**CITY OF PORTLAND, MAINE
DEVELOPMENT REVIEW APPLICATION
PLANNING DEPARTMENT PROCESSING FORM
DRC Copy**

Maggie Lane lot # 20 duplex
Project Name/Description

Approval Conditions of Planning

Approval Conditions of DRC

Drawing Name:	Grading & Drainage Lot 20
Project:	MAGGIE LANE DEVELOPMENT, LLC.

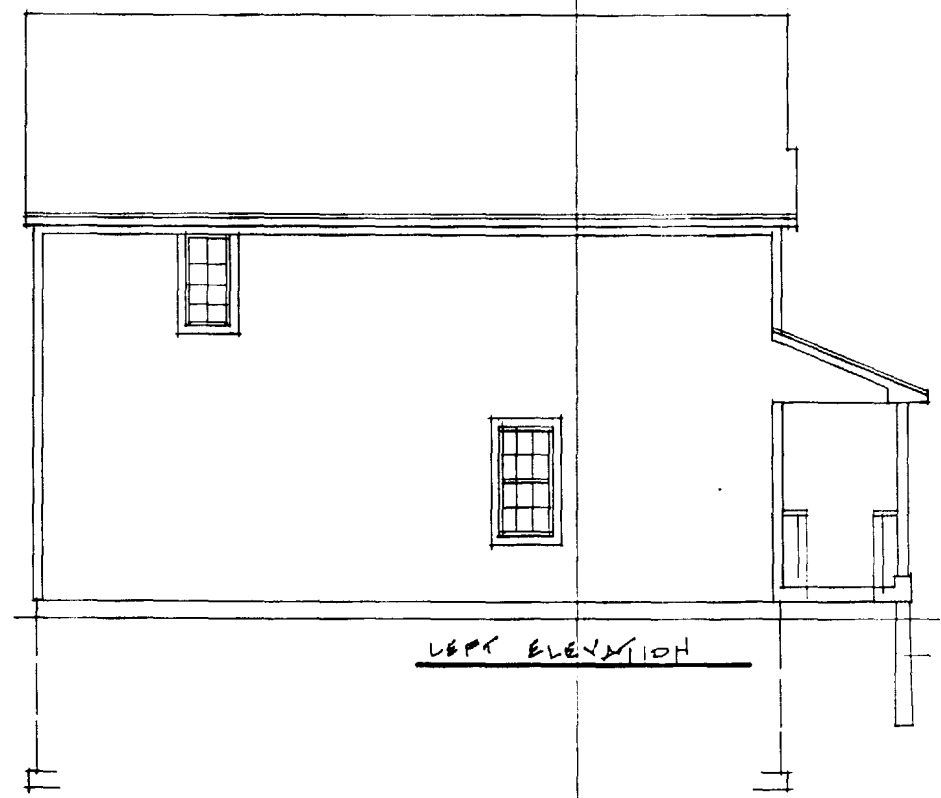
- 1 GRADING SHOWN ON PLAN WILL CREATE PONDING OF WATER ON LOT 19 (UNBUILT). CONDITION WILL BE CORRECTABLE BY THE DOING THE FINAL GRADING OF LOT 19 ONCE IT IS BUILT.

LEFT ELEVATION

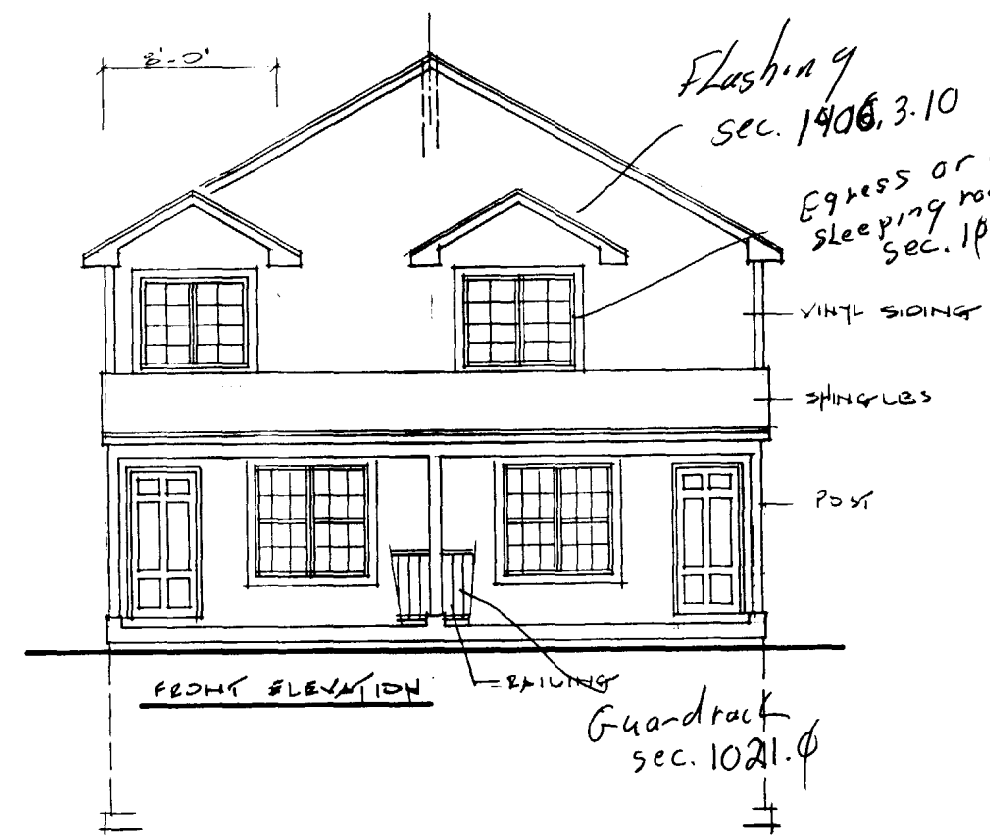
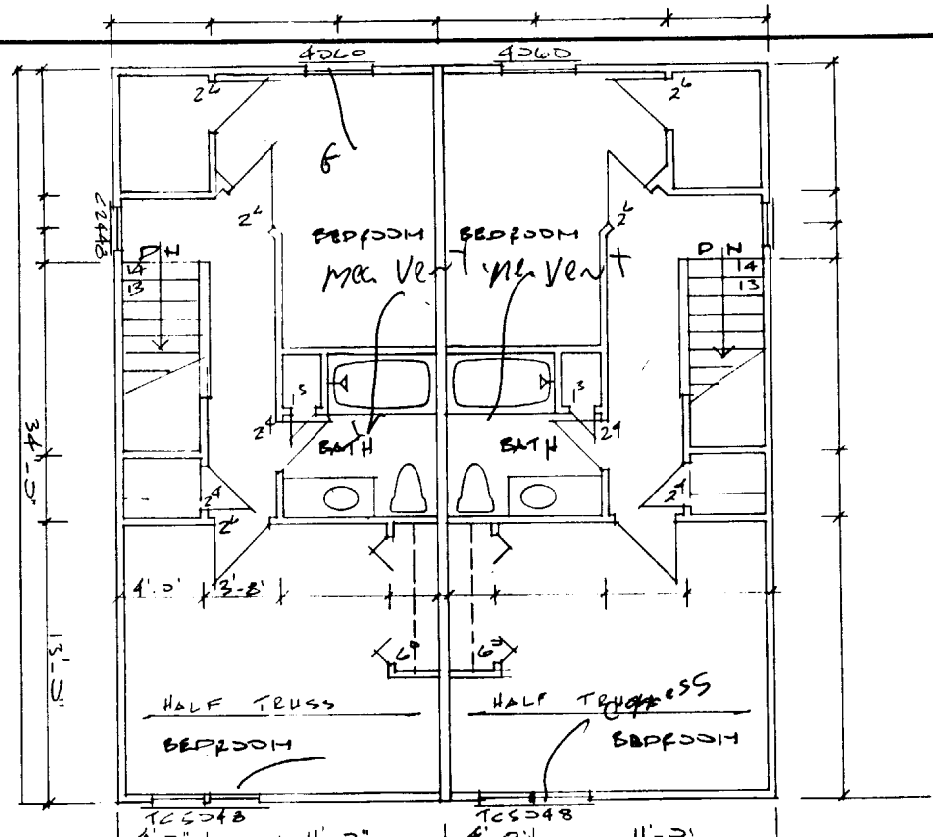
- 1 The roof shall have a minimum of 7 in 12 pitch.
- 2 The right and left building elevation shall have a minimum of 3 windows per side.
